Town and Country Planning Act 1990 (As amended)
Town and Country Planning (General Permitted development) Order 2015 Schedule 2 Part 1
Class A
Application for Prior Notification for a householder extension

Development Notification under extended permitted development rights for a single storey orangery from the rear wall wall by 5.3m with a maximum height of 3.2m and an eaves height of ???

Location 47 Ivy Lane Westergate

AS EXISTING.

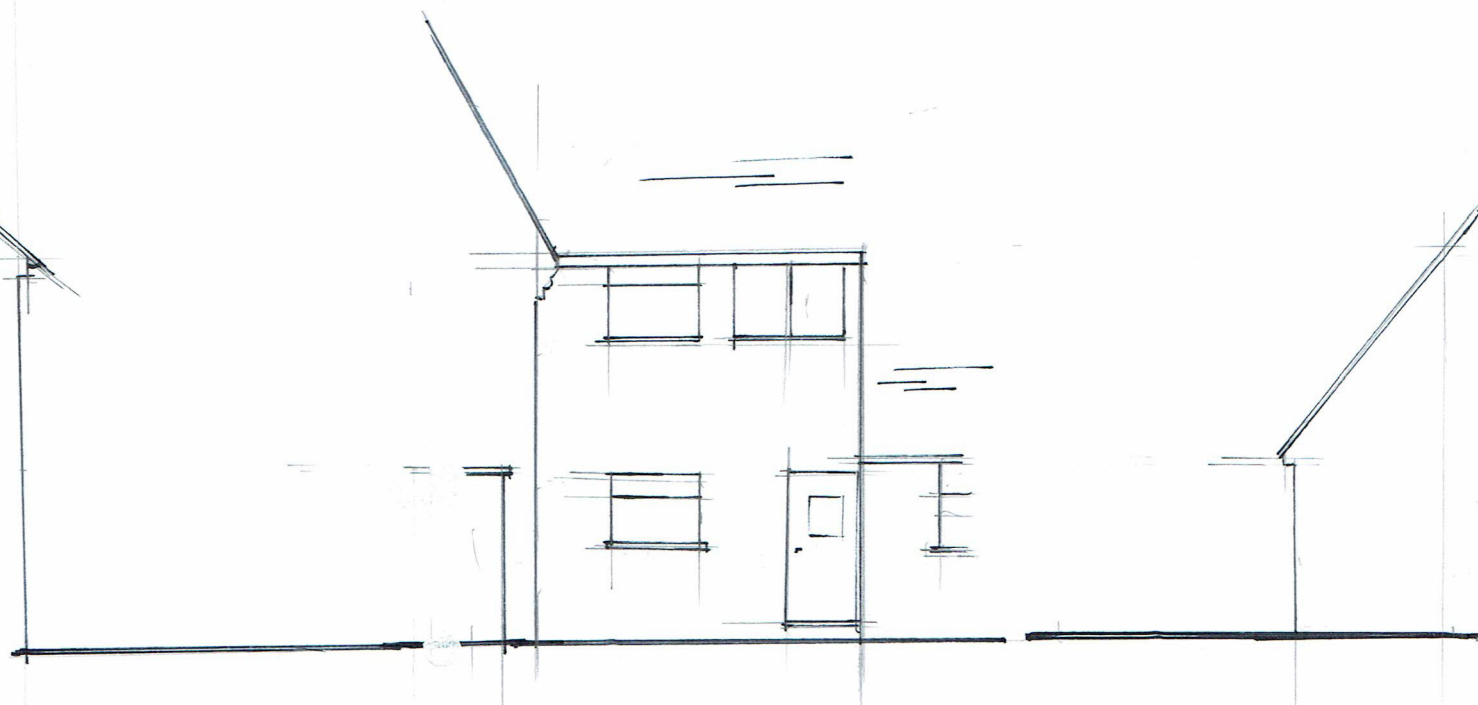
Please provide existing and proposed floor plans and elevations of the property the extension is going on to show the house as existing and then as proposed.

AS PROPOSED

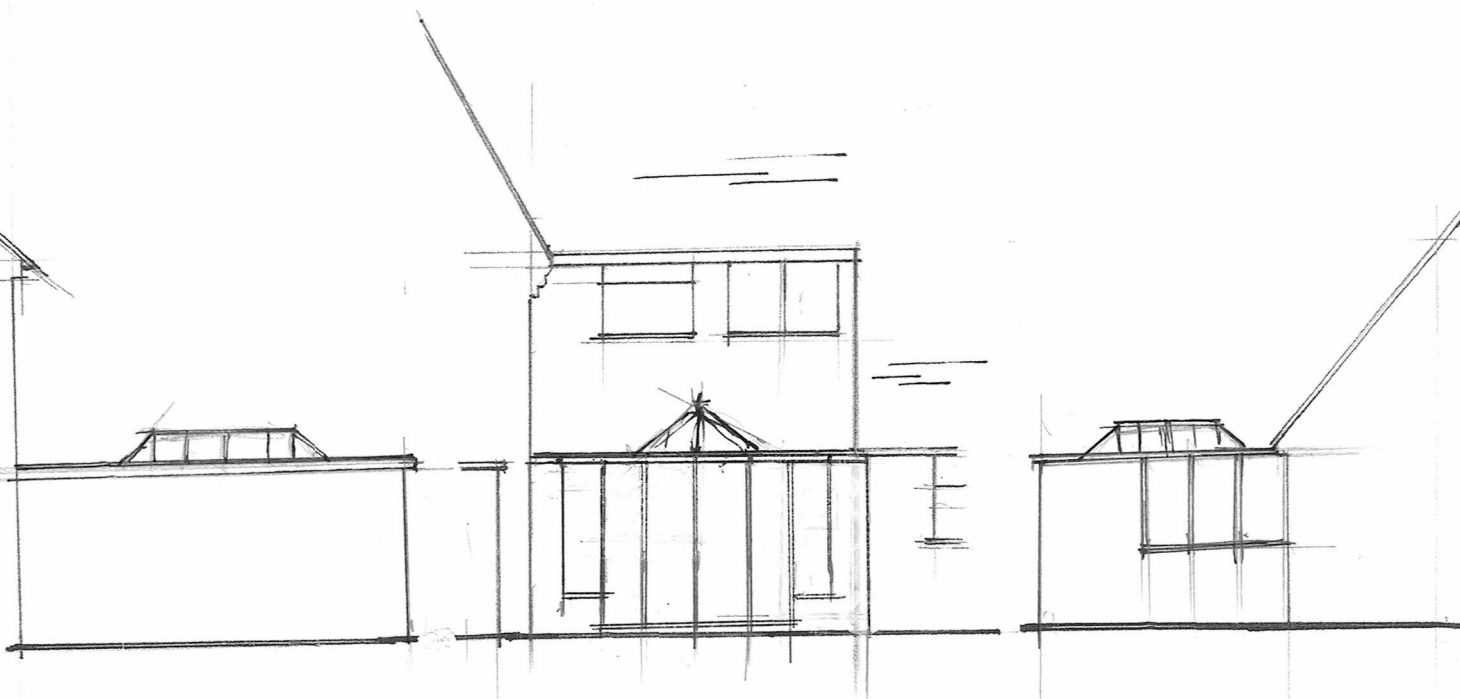
Please complete the remainder of Q4 on the application form (provide us with the height of the eaves of the proposed extension). Please also confirm that there is no existing rear extension on the property and this proposal will be attached to the original rear wall.
